# Charlotte Department of Transportation

## Memorandum

**Date:** January 5, 2006

**Subject:** Rezoning Petition 05-108: Located on the west side of Beatties Ford Road, south of McIntyre Avenue (revised 12/15/05)

SITE PLAN

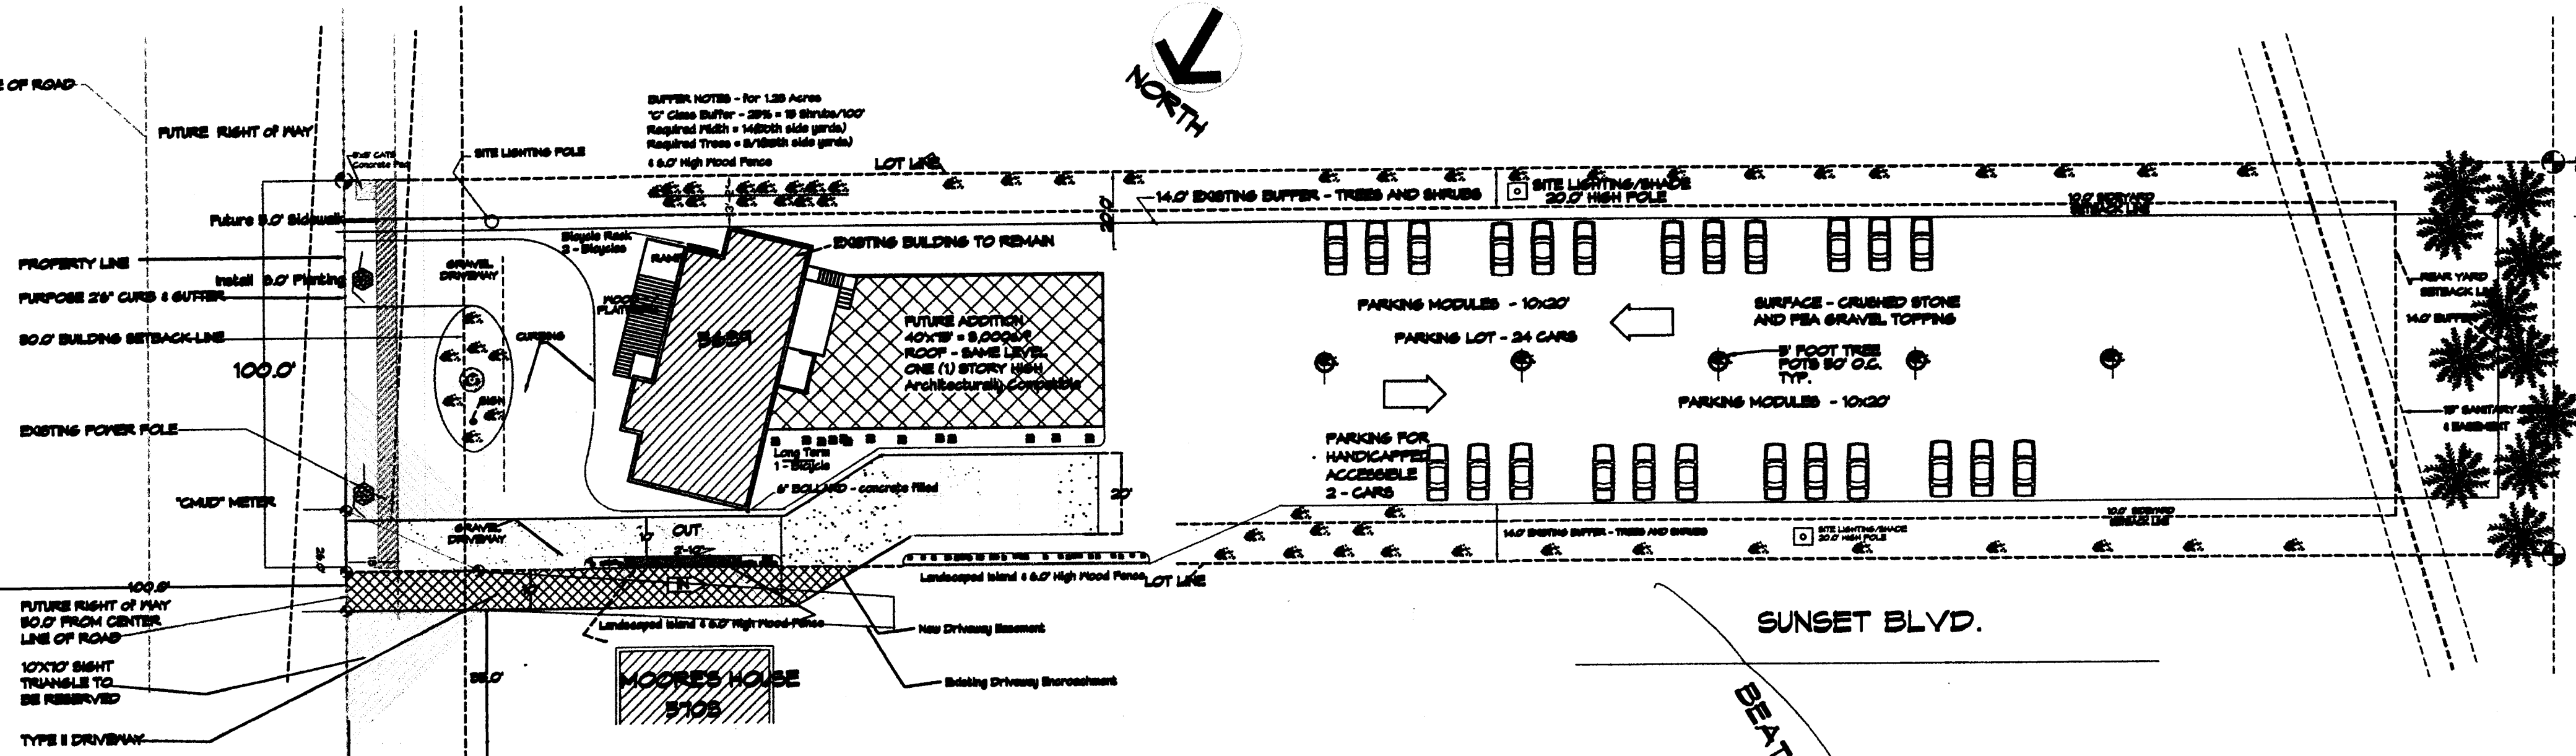
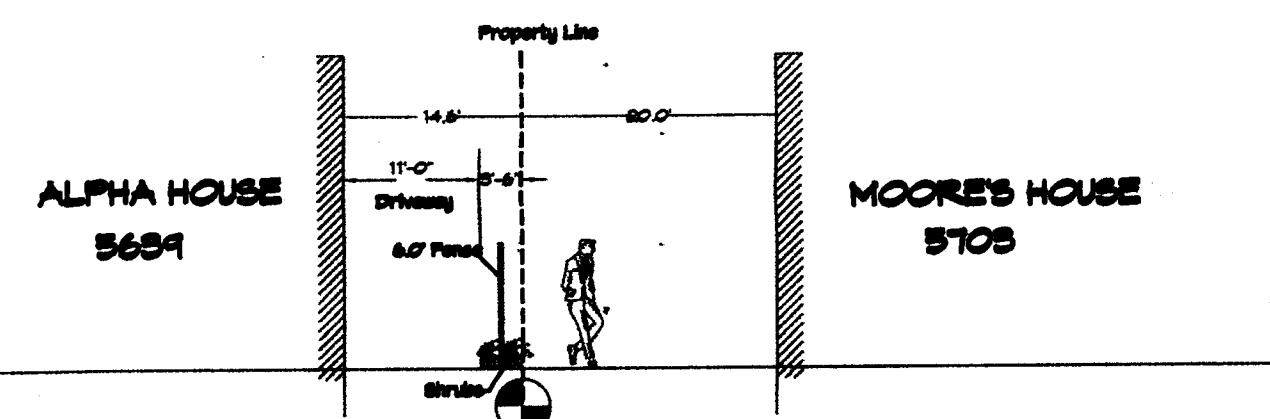
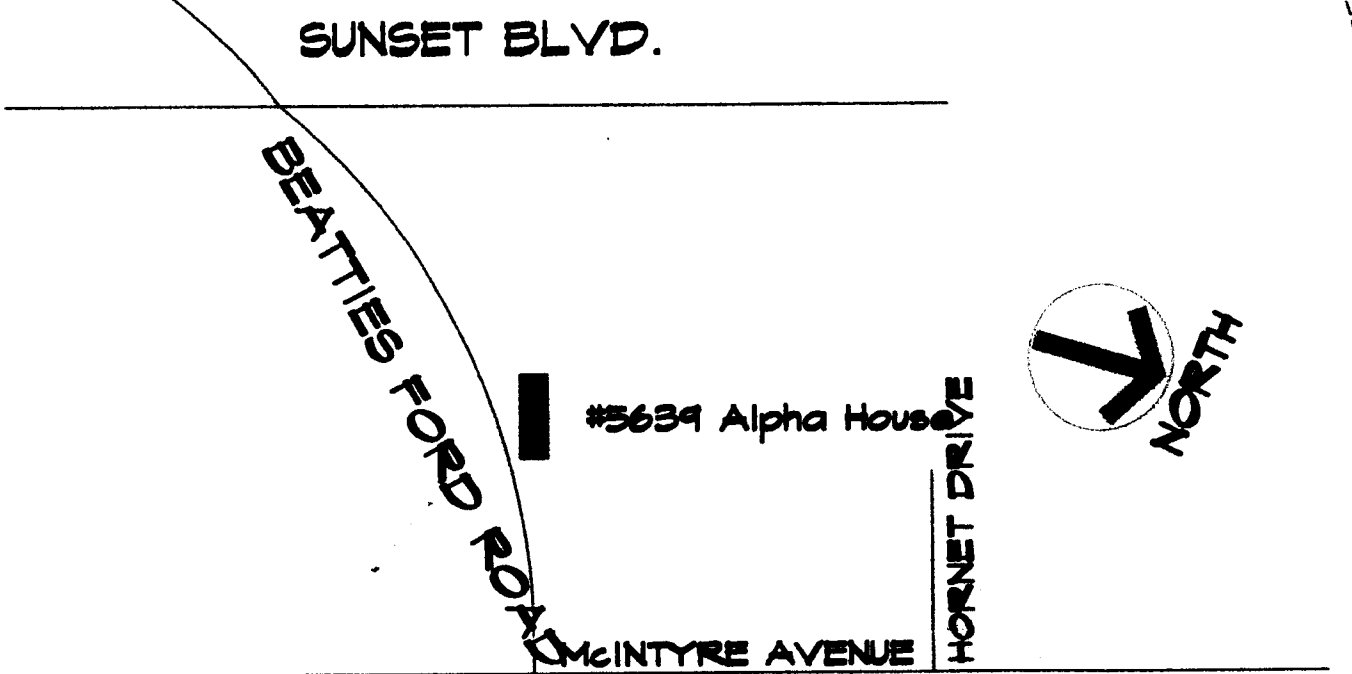
1. The cross-section between the buildings shown on the site plan gives a total dimension of 48 feet between buildings, but scales as approximately 35 feet. This discrepancy needs to be resolved.
2. The callout indicating "reserved for 8' planting strip and 5' sidewalk" is unclear. Does the petitioner intend to construct this section? If so, a conditional note committing to construct an 8-foot planting strip and 5-foot sidewalk needs to be added to the plans.
